EPA Submission on Planning Advice Request

Thank you for the request for advice on Public Authority Consultation (PAE-35233728). The Department of Planning and Environment (DPE) has requested a review by the NSW Environment Protection Authority (EPA) of the Environmental Impact Statement (EIS) and the Proponents Response to Submissions for the proposed Sancrox Quarry Expansion Project (Application SSD-7293) at Sancrox Road, Wauchope, NSW

NSW Environment Protection Authority (EPA) Submission on Response to Submissions Report for proposed Sancrox Quarry Expansion Project (Application SSD-7293) at Sancrox Rd, Wauchope, NSW

Public Authority Consultation (PAE-35233728)
10 February 2022

F1.2

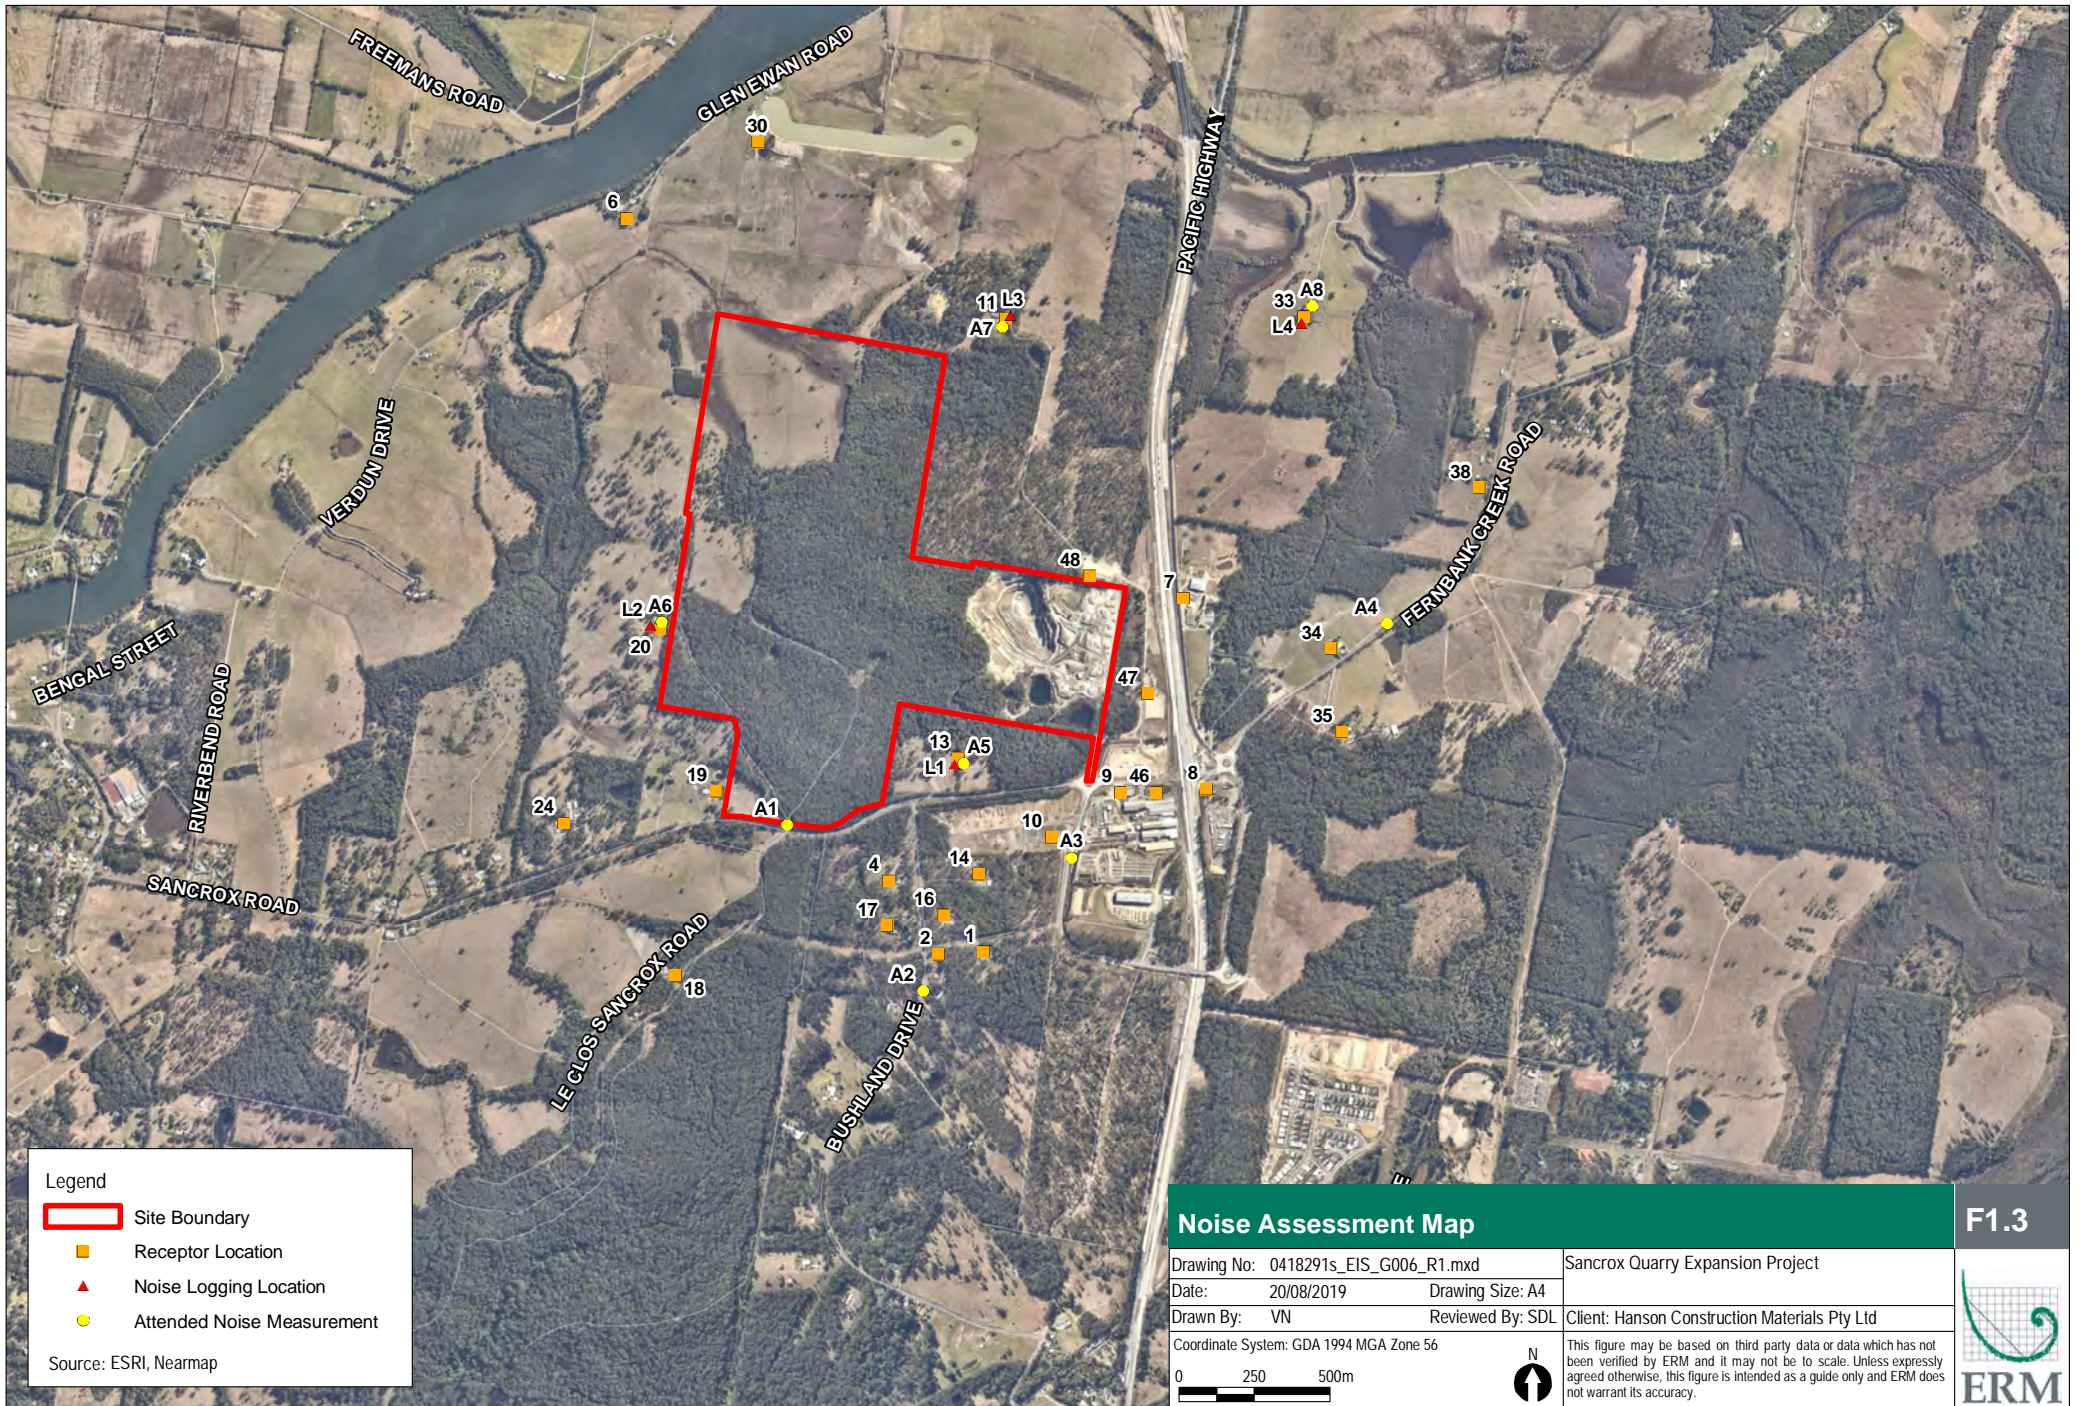
- L6.1** Noise generated at the premises must not exceed the noise limits at the times and locations in the table below. **PROPONENT TO CONFIRM ADDRESSES AND LOT DPS UPDATED NVIA FIGURES 1.2 and 1.3 do not match receiver locations and Table 3.1 appears to have errors in the coordinate system.**
